29 January 2025

Jessica Watson
Senior Environmental Assessment Officer
Department of Planning, Housing and Infrastructure

State Significant Development - Pottinger Wind Farm - Major Project reference: SSD-59235464

09F - Broken Hill Bypass Option 3

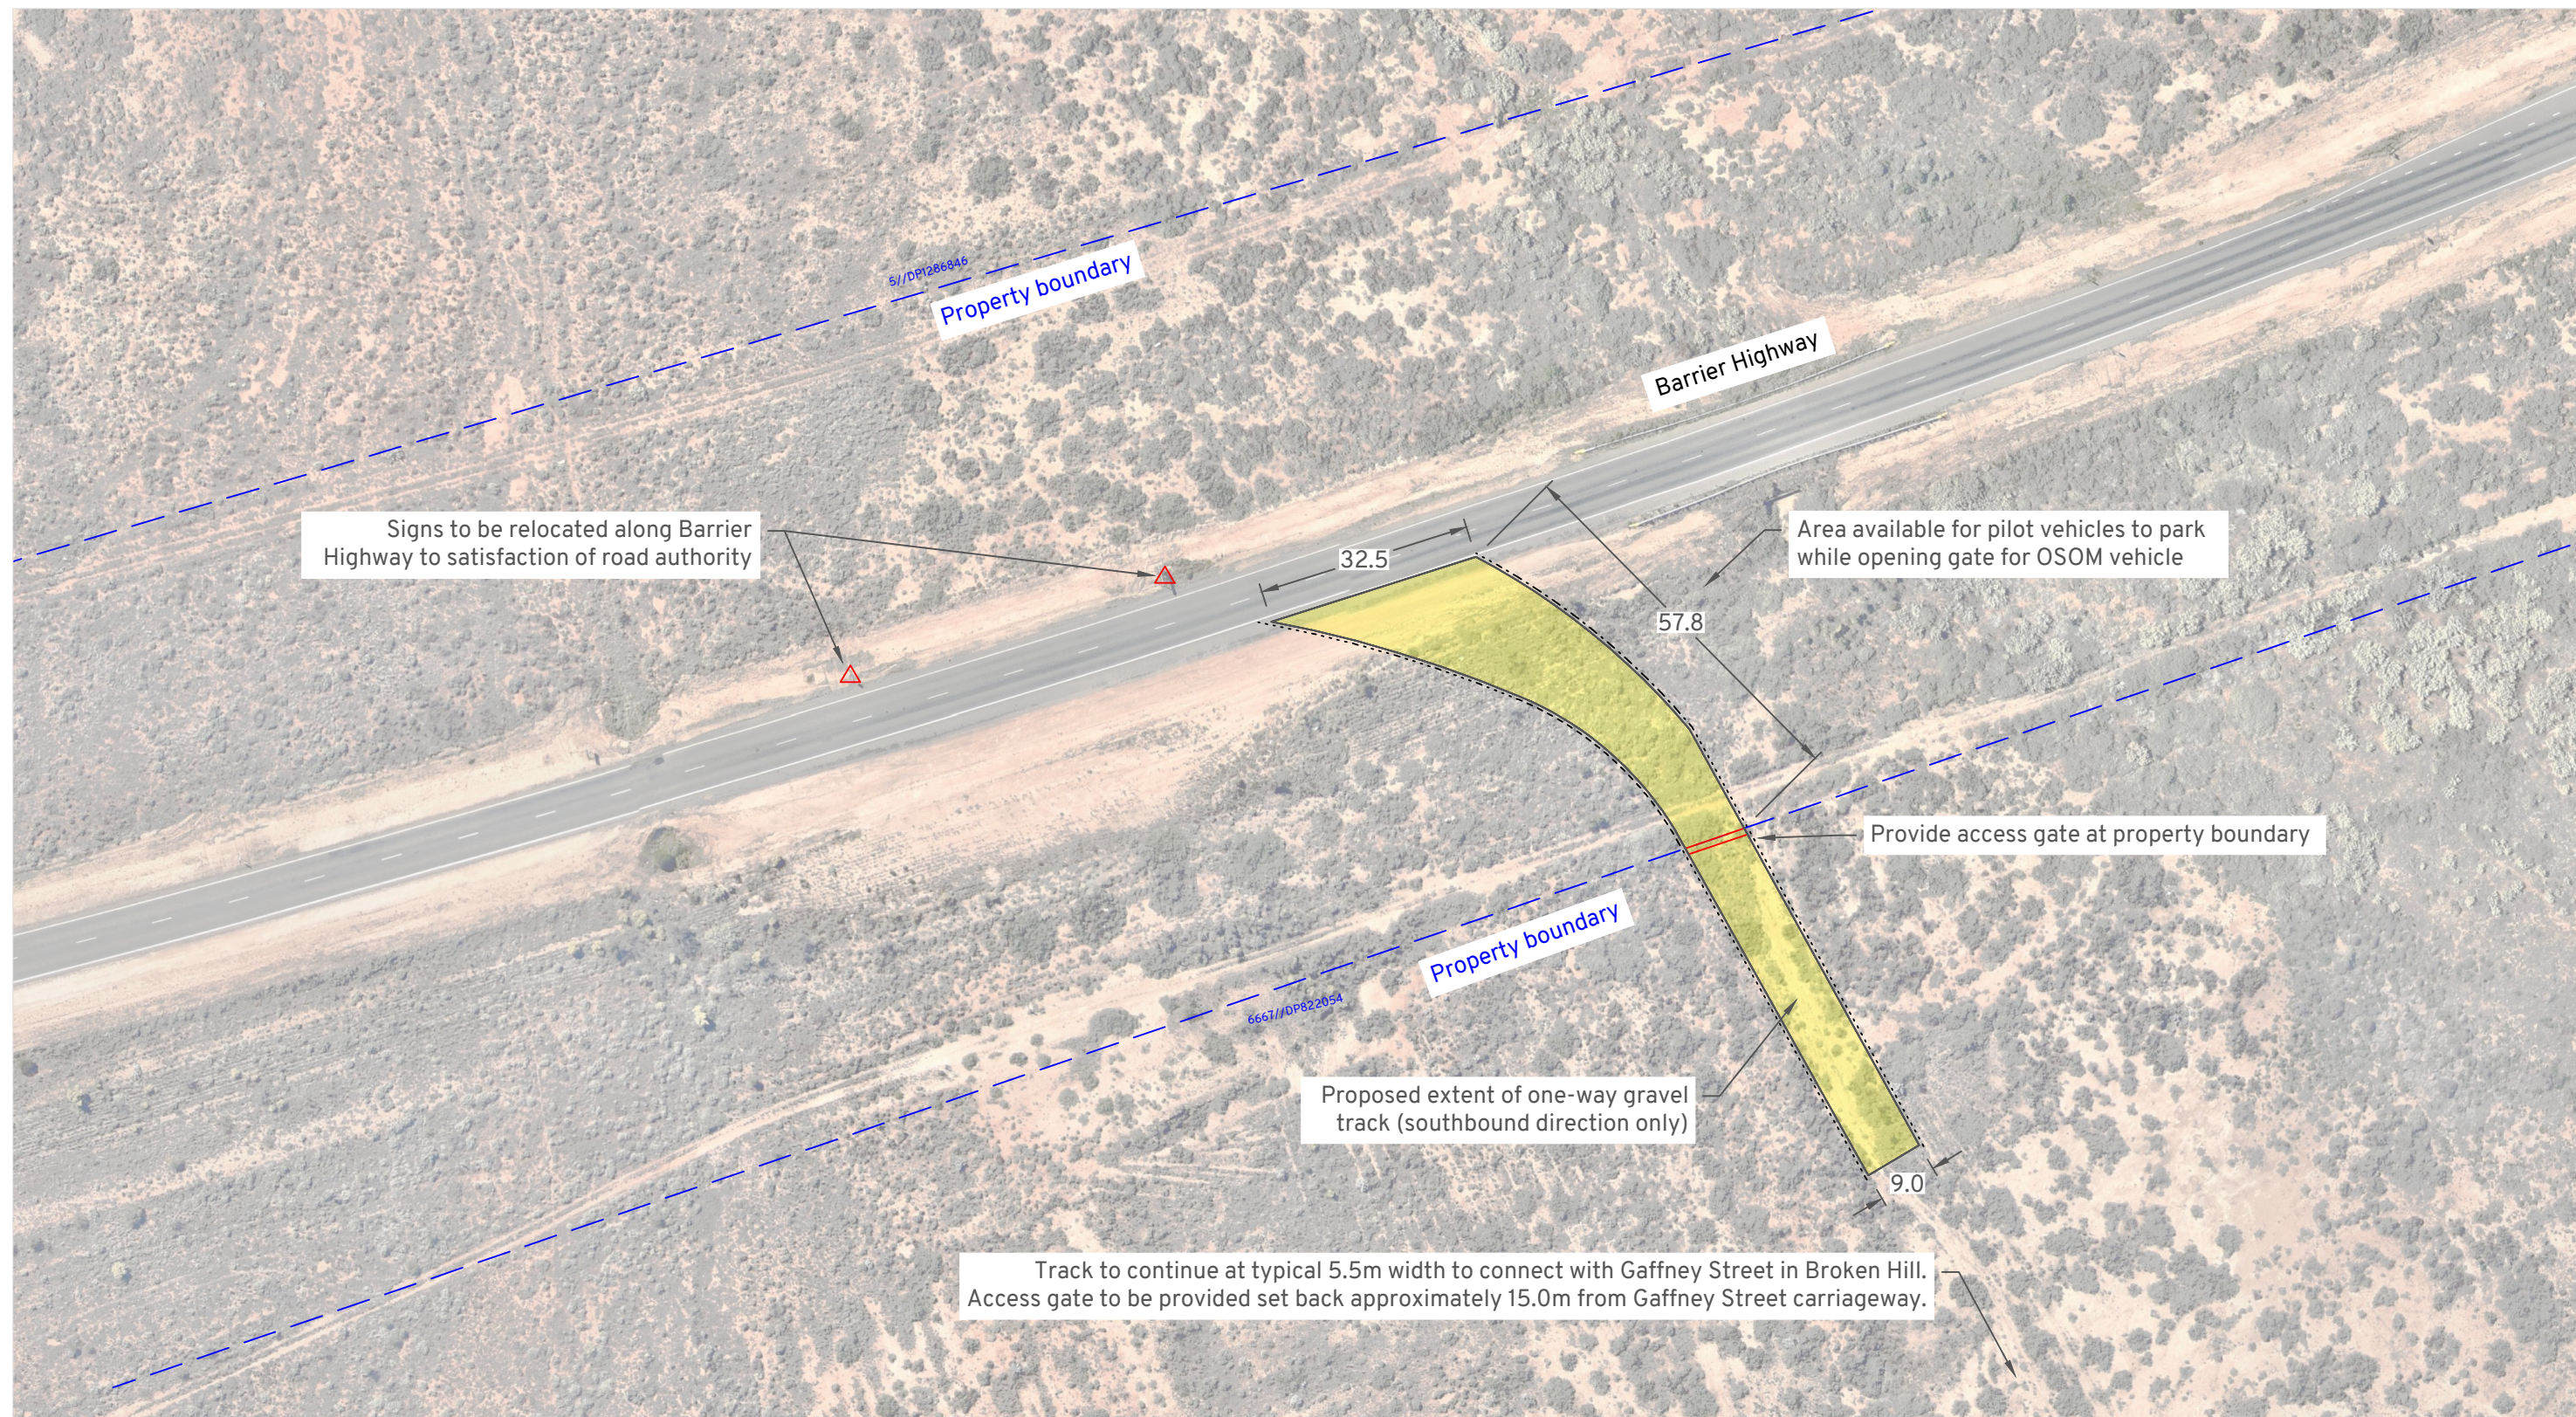
- Council requests clarification be provided by the proponent as to whether the temporary bypass from the Barrier Highway in the Broken Hill LGA, is to be removed.

10B - Chettle Street / Barrier Highway, Broken Hill
Strategic Design
Pottinger Wind Farm

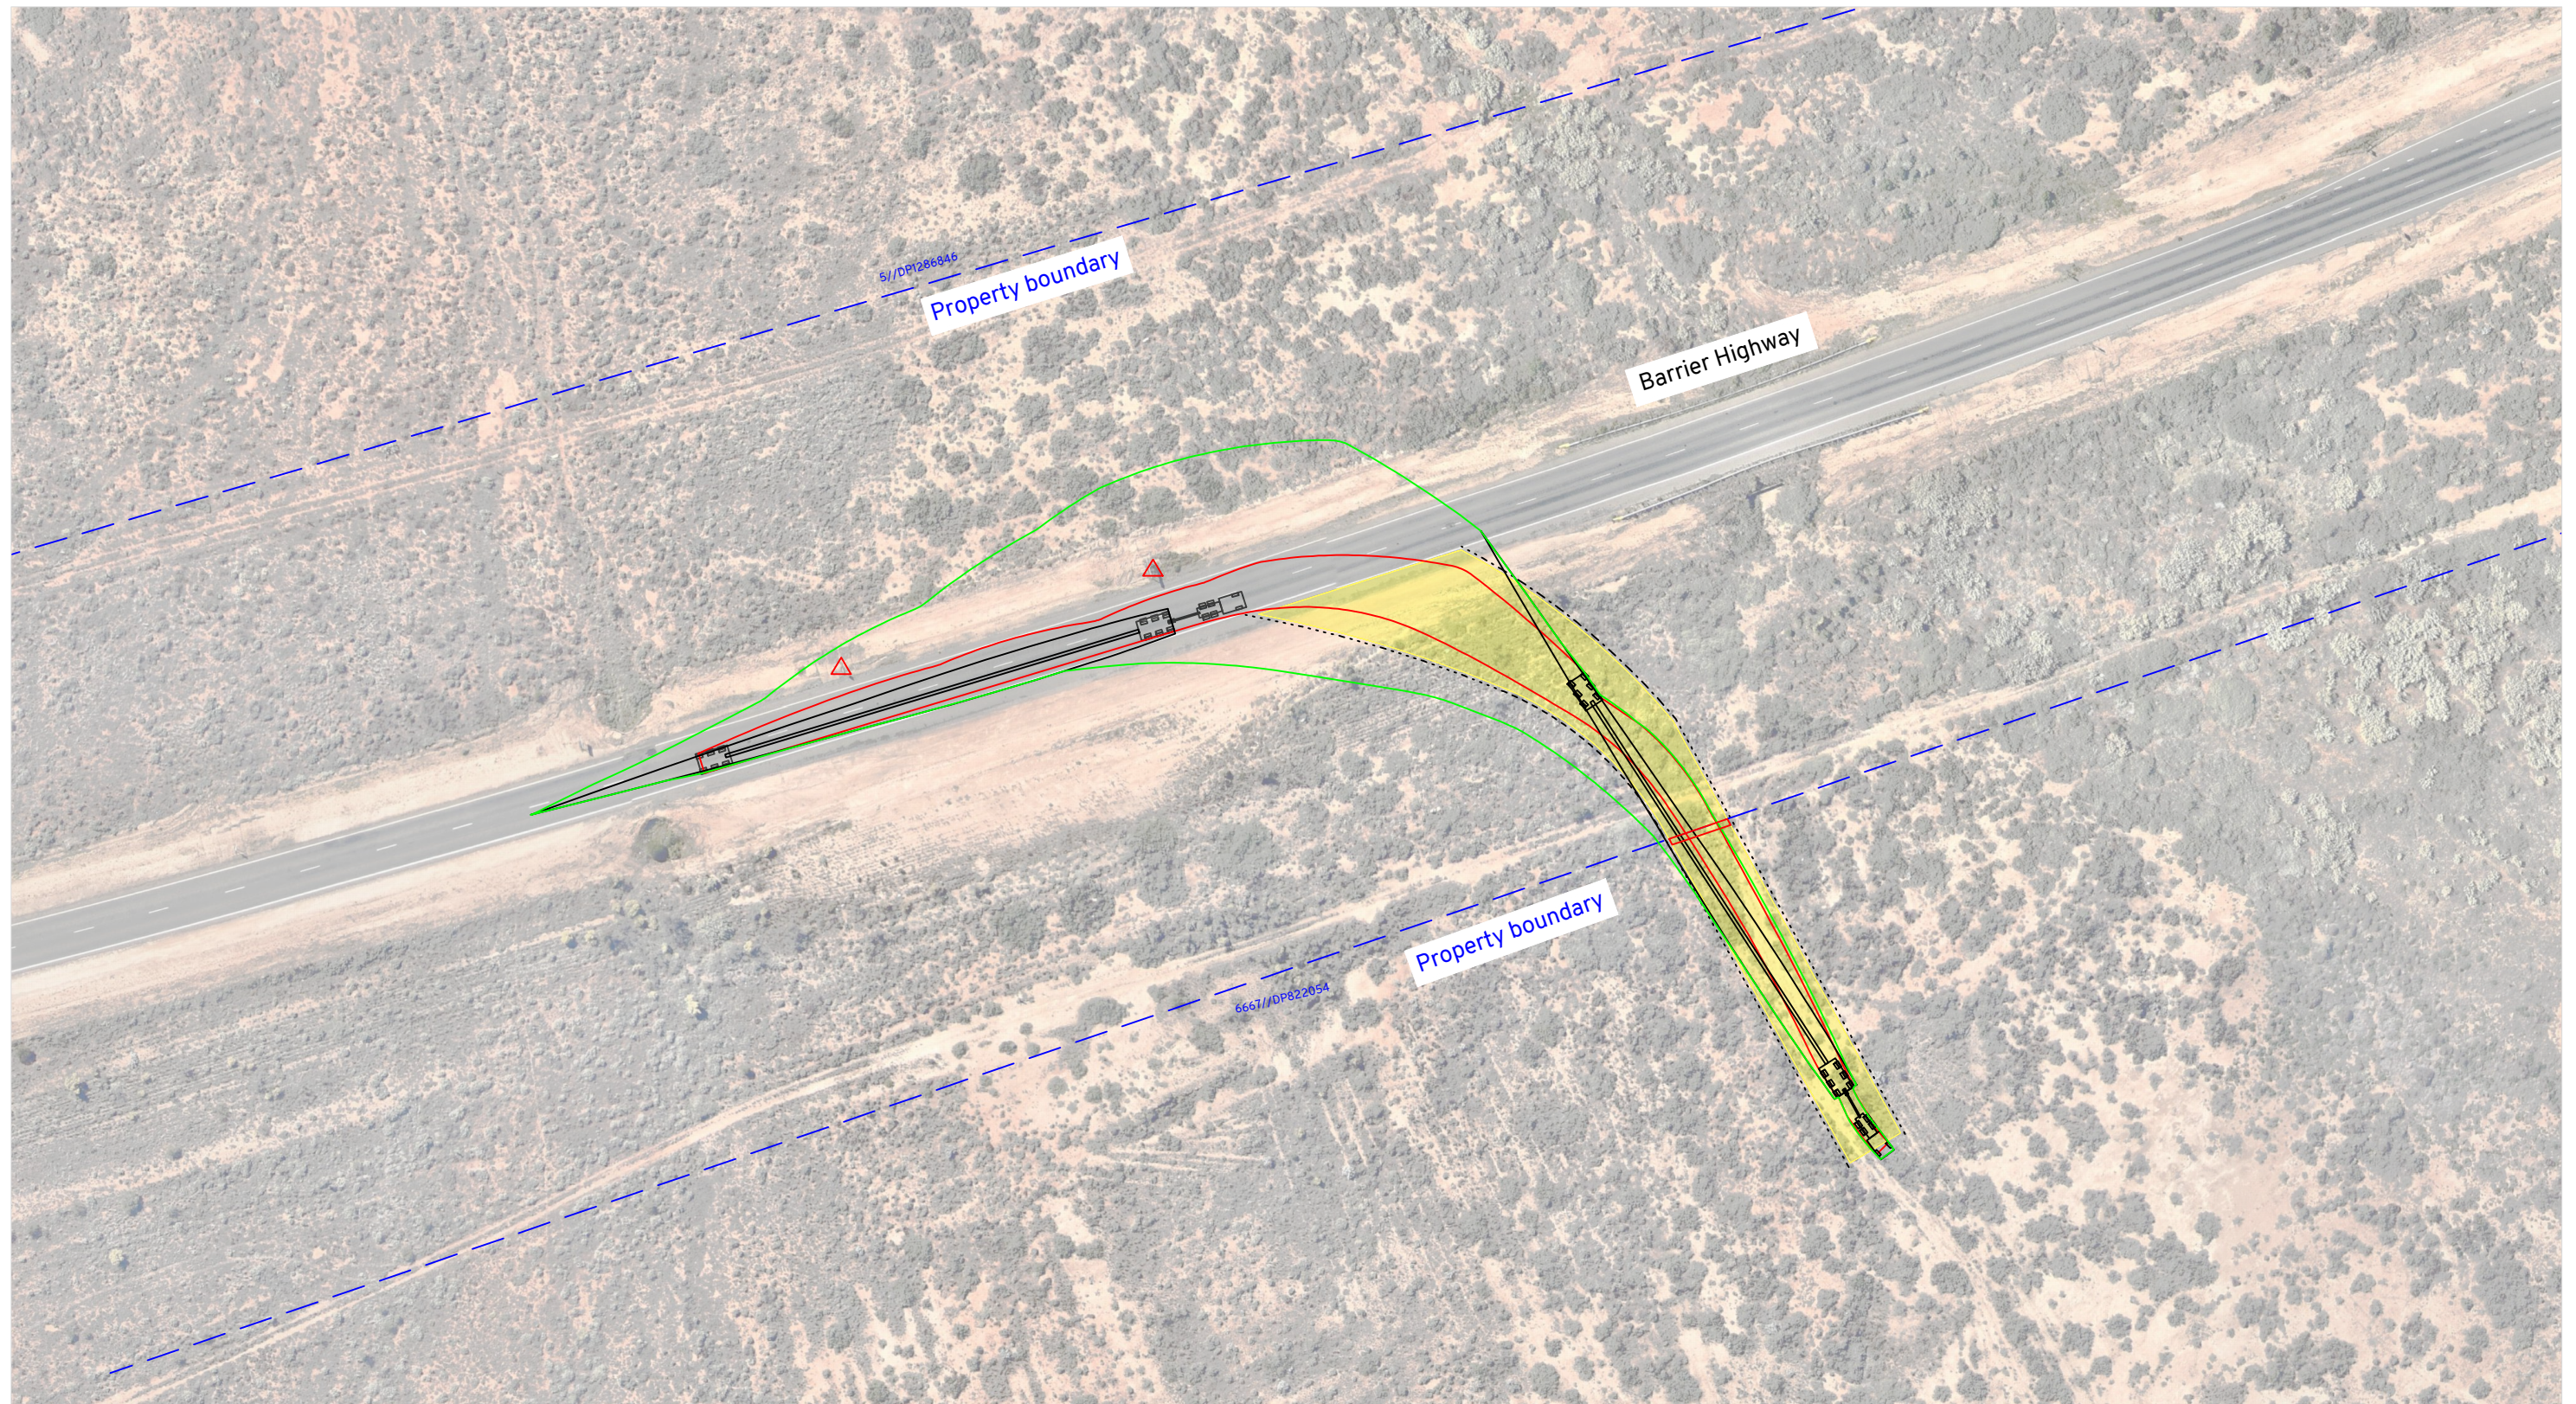
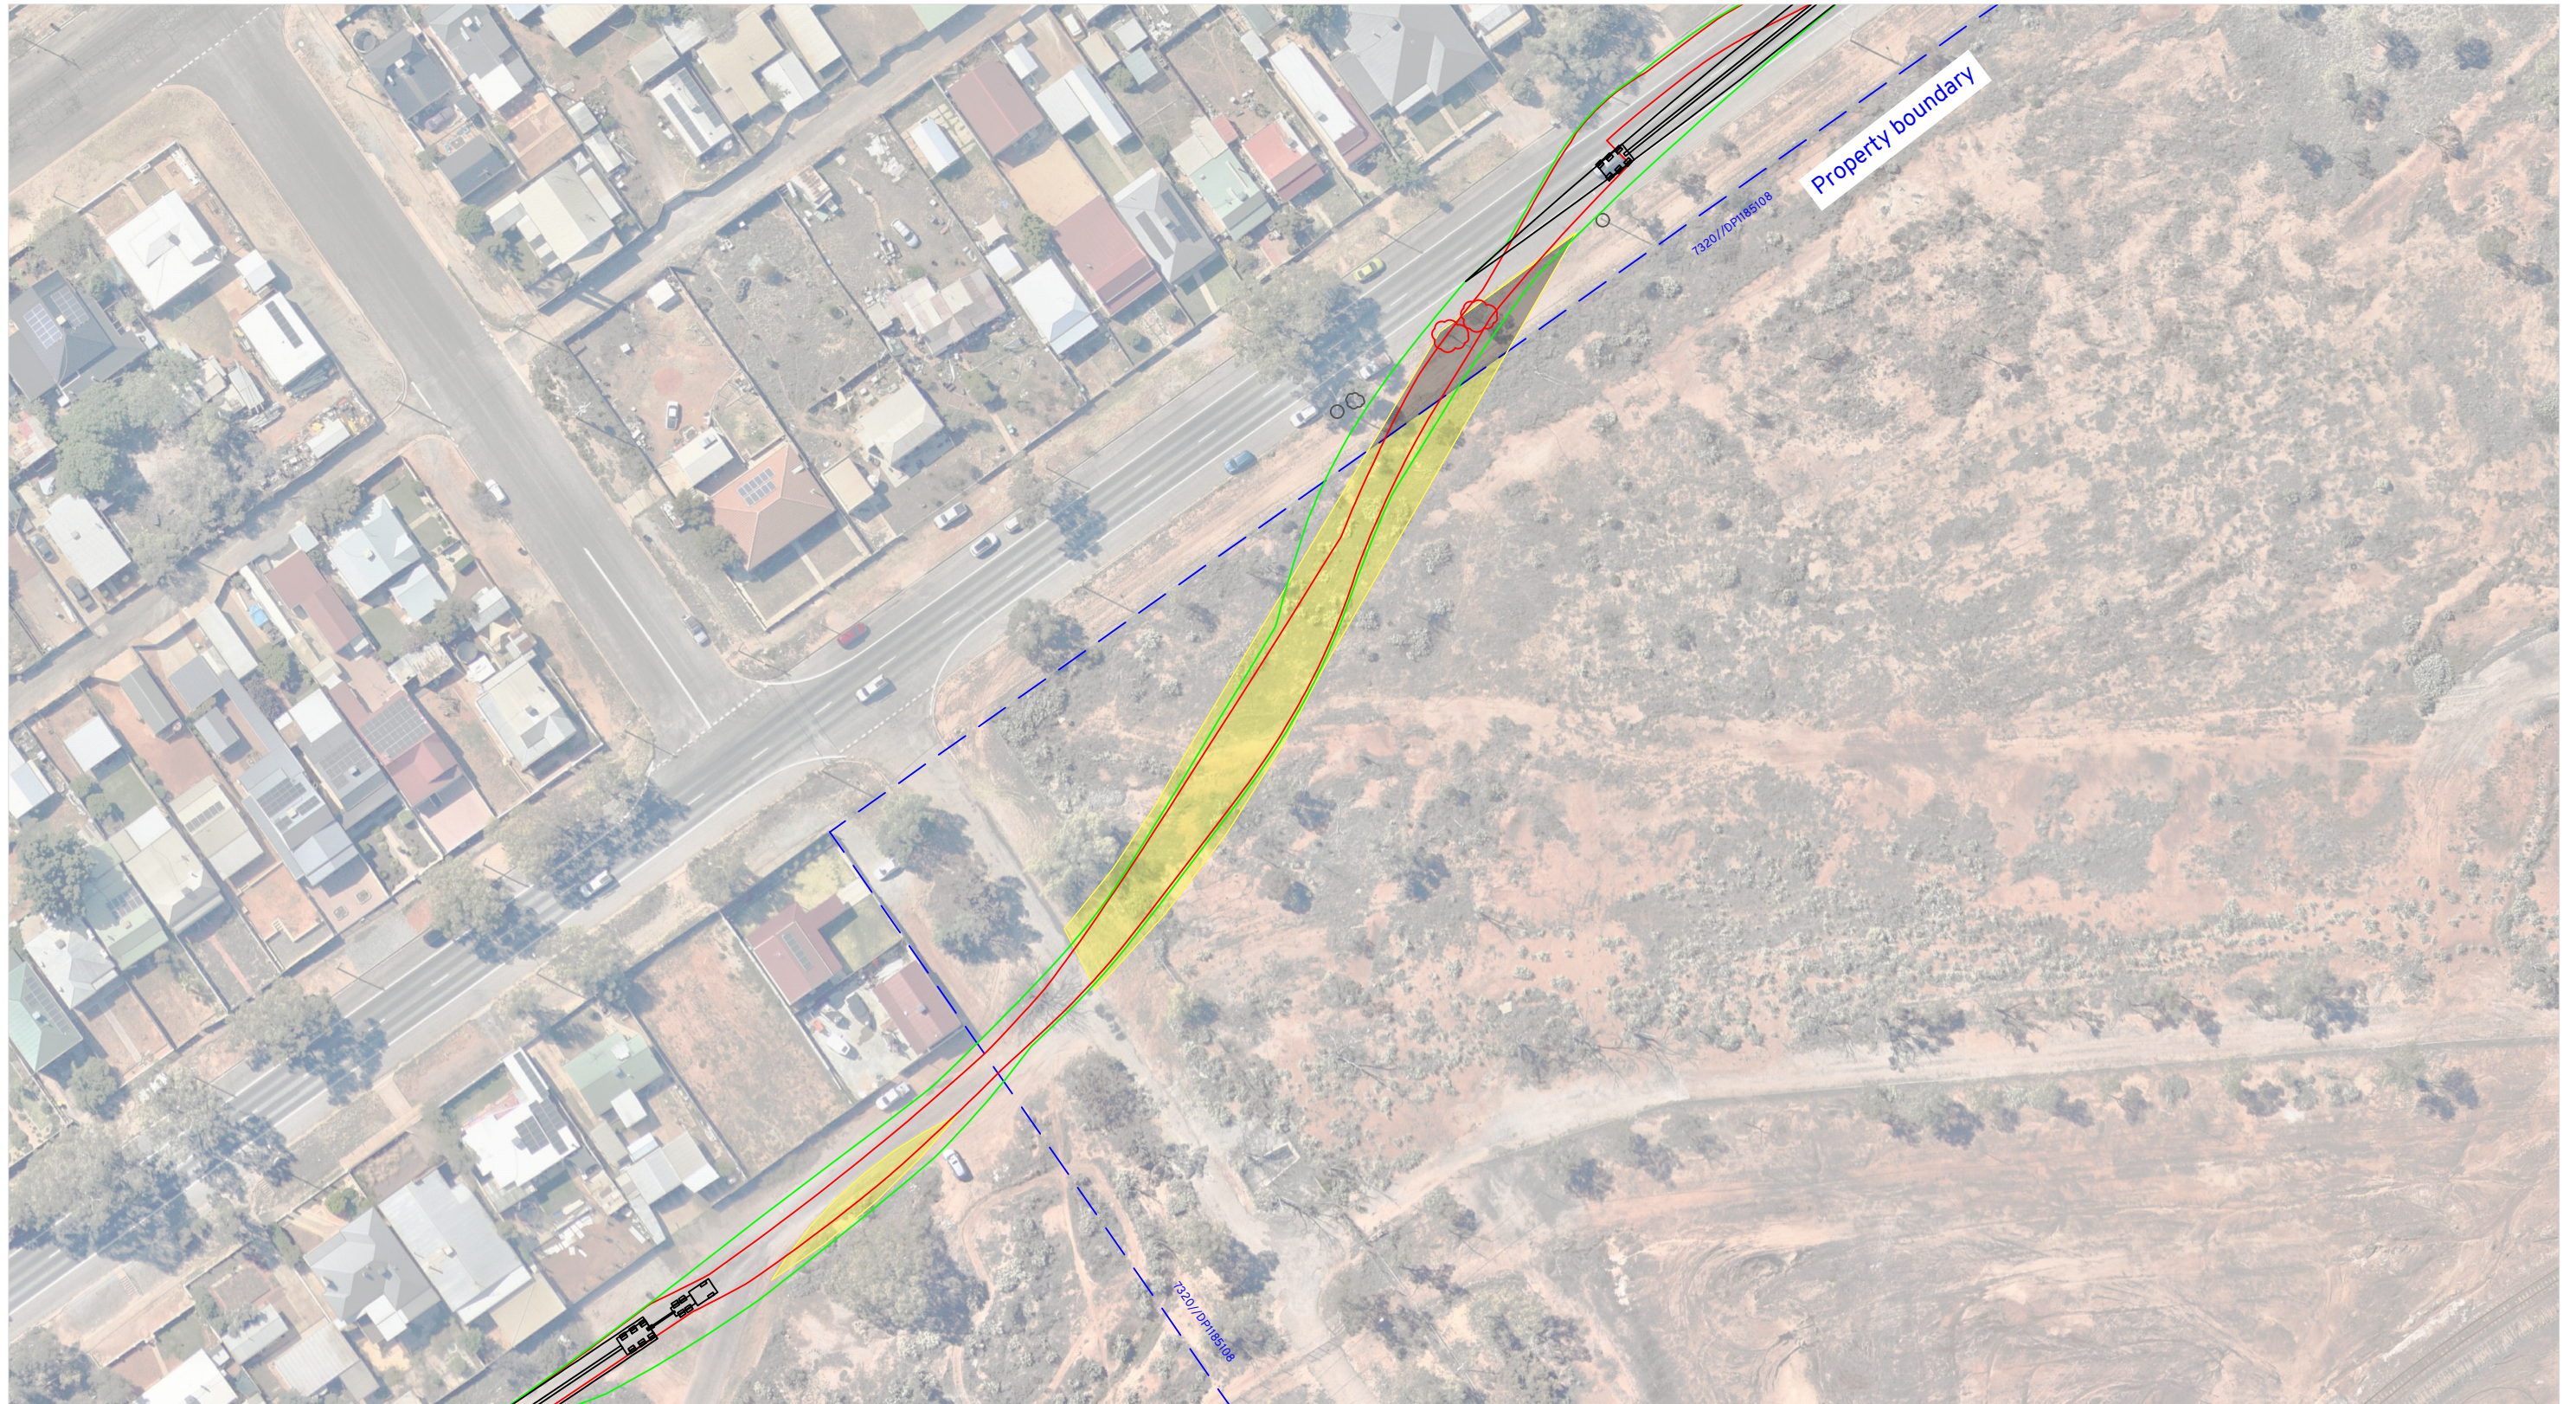
- It is noted that the transport route near the area of Sturt/Chettle Streets and Barrier Highway (Lot 7313) requires fencing to be re-aligned and new gate installed. It appears that this area may cut through a Mining Lease, of which Perilya Pty Ltd has an interest in ("Broken Hill North Mine"). Council suggests that the consent Perilya be sought prior to DA consent being issued.
